From: Peter Cleveland
Sent: 17 July 2013 08:34
To: Sonia Gibbon [REDACTED]
Subject: FW: Forge Cottage driveway - LU/208/12
Attachments: LU-208-12.pdf

Subject RE: Forge Cottage driveway - LU/208/12

SITE PLAN 1:100

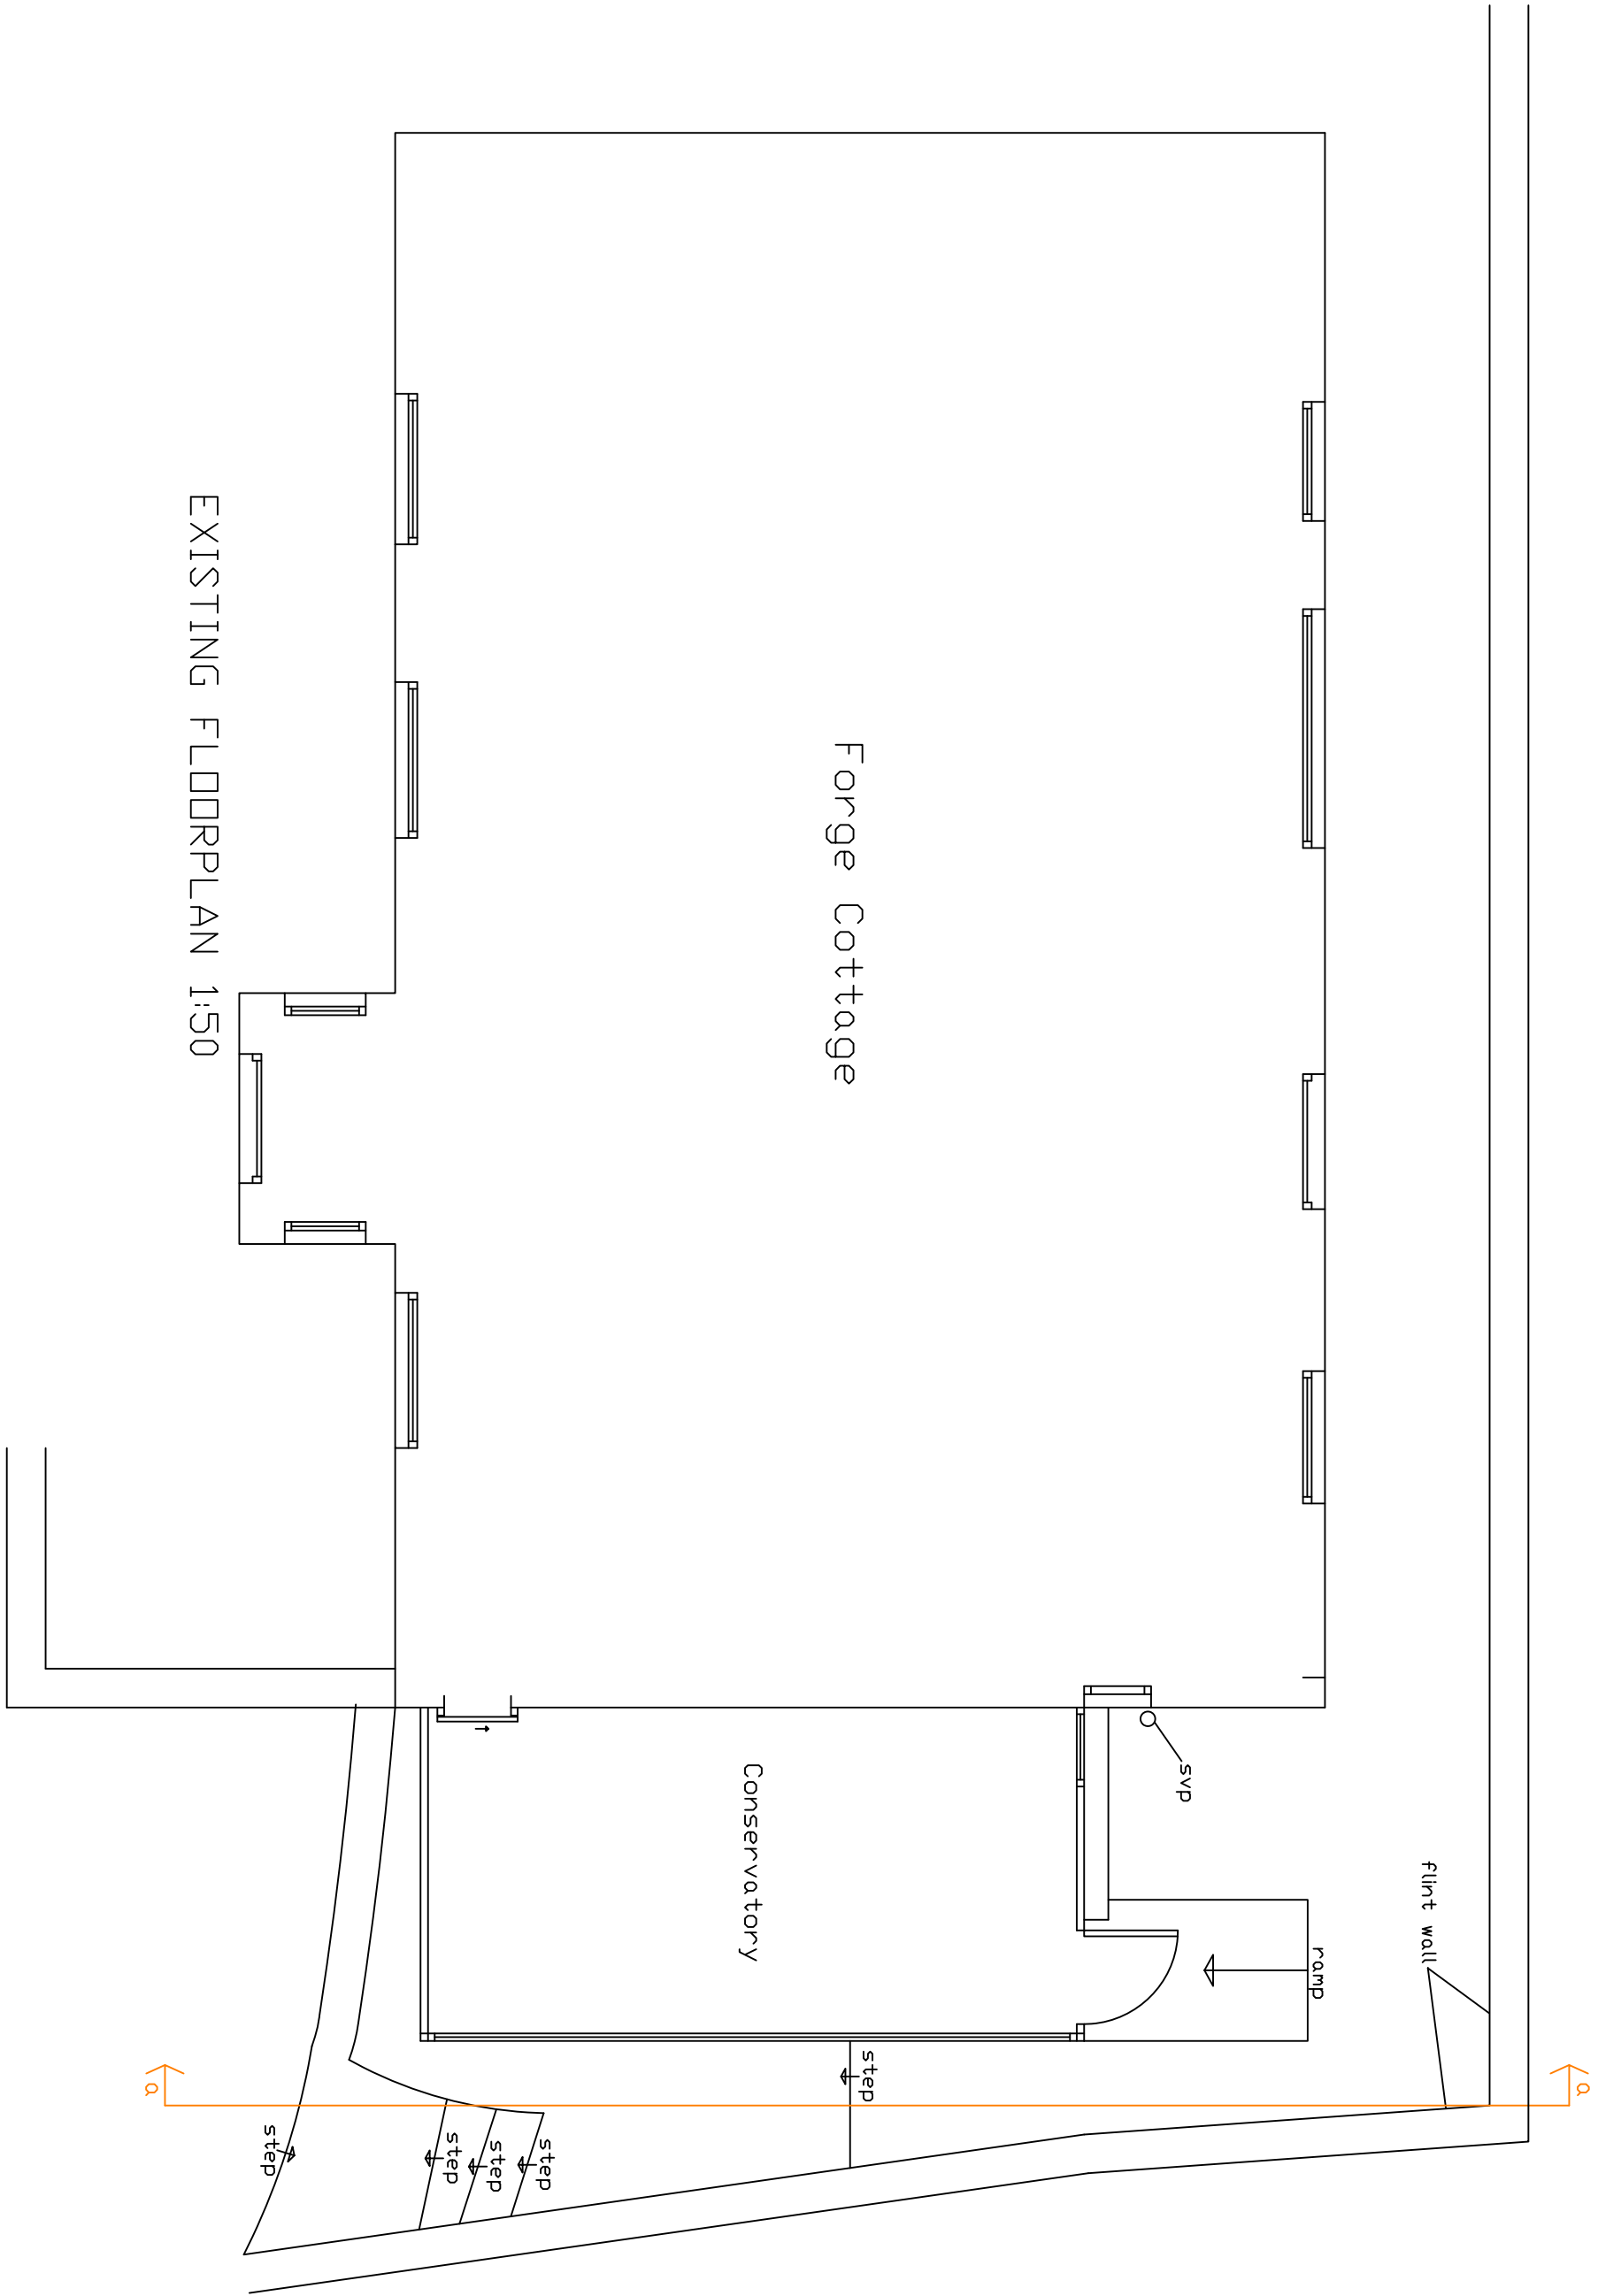
Jamie, I have copied you in on for your confirmation that the 1:100 Site Plan on the attached PDF would meet your requirements for pedestrian visibility splays, ref Condition imposed by the Planning Inspectorate upon your recommendation.

I've spoken to the people who drew the plans and they confirm that the section in the top right was a response to Highways asking them to show the standard visibility from the drivers seat - with reference to whether I would be able to see pedestrians from my driveway. This is why the wall should not be greater than 600m. I believe this shows that clearly.

I have looked at the plan and would agree that it is acceptable for the condition to be discharged for pedestrian visibility.
